New Request for Advice on EIS – Trinity Grammar School Redevelopment (SSD-10371) (Inner West)

Proposal: Trinity Grammar School – Summer Hill Campus The ‘Renewal Project’

Property: 113 – 119 Prospect Road, Summer Hill Lot 11 DP 1171965

01 PLAN
DA141 Level 0 Proposed
Scale 1:200

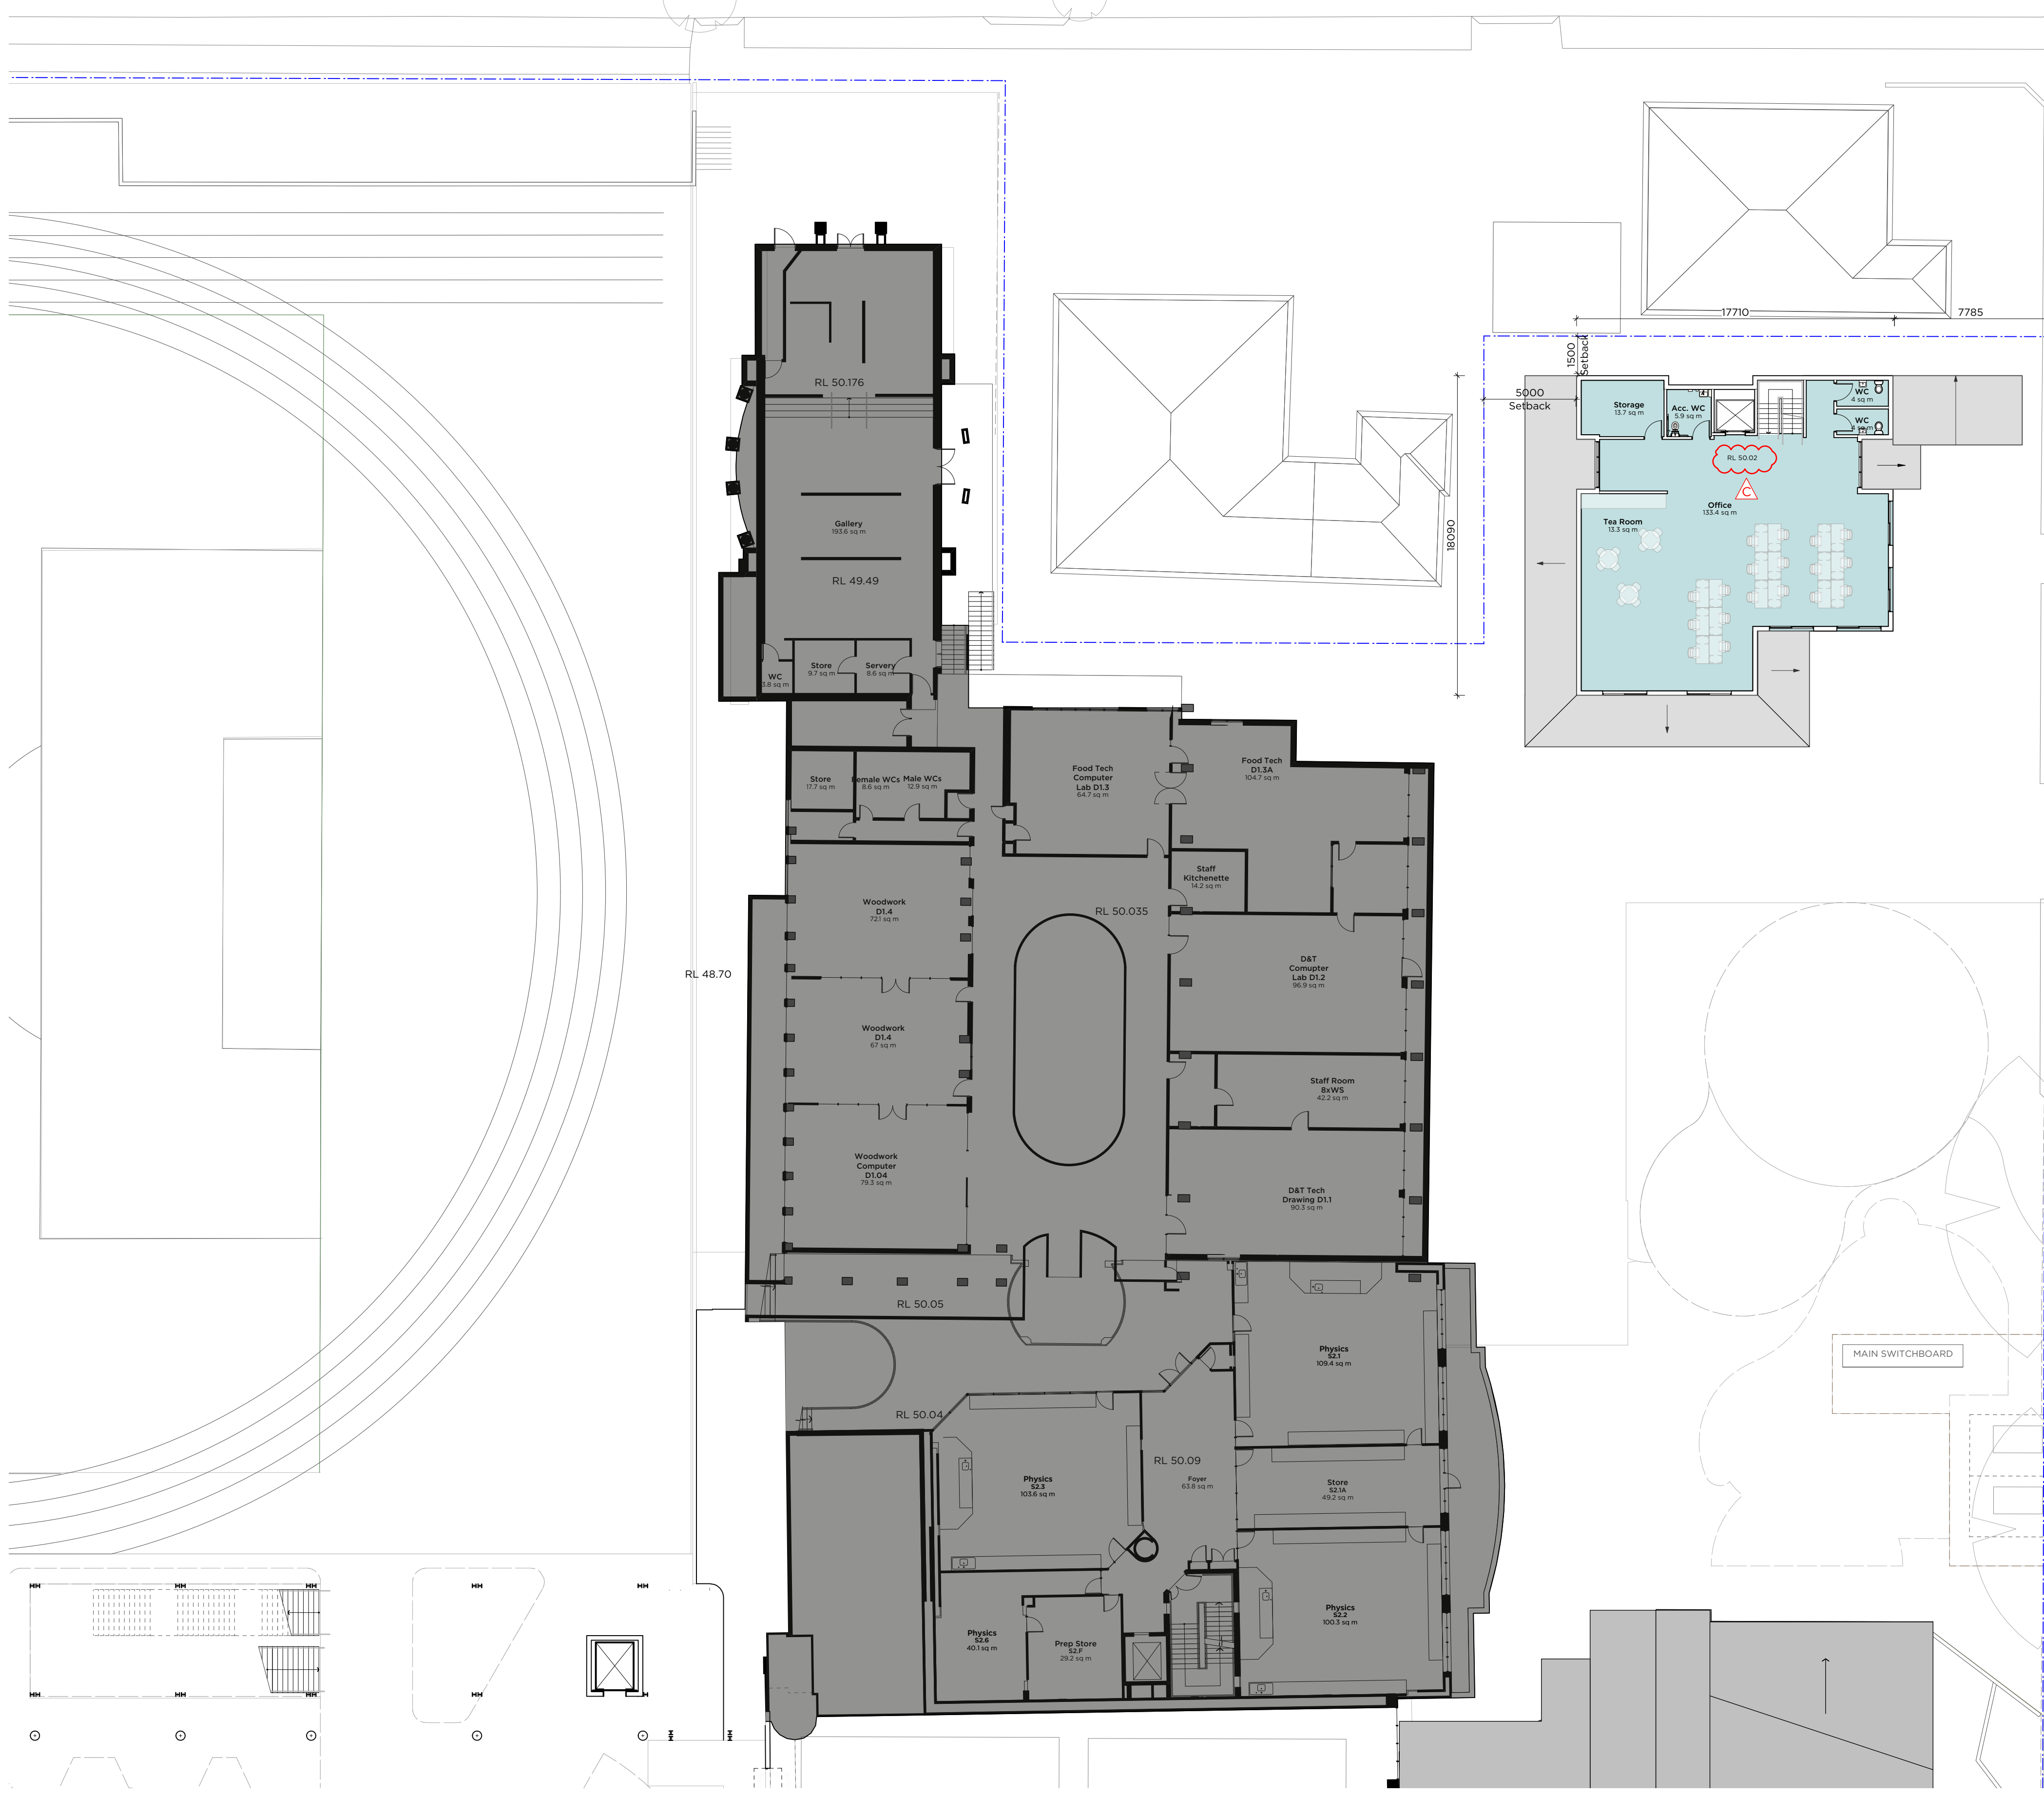
No objection is raised to the new delivery/ loading bay accessed from Seaview Street, subject to the concerns raised under subheading Seaview Street Streetscape below being addressed and resolved.

The proposal seeks consent for the demolition of at least four (4) existing dwellings along Seaview Street and the construction of a new Maintenance Building and a loading dock for deliveries. The plans fail to provide sufficient details with regards to the development along Seaview Street. Critical information such as detailed elevations and streetscape analysis have not been provided and therefore a comprehensive assessment of the impacts of the proposal on Seaview Street cannot be made. Additional information regarding the proposed maintenance building and streetscape analysis for Seaview Street must be provided to enable a detailed assessment.
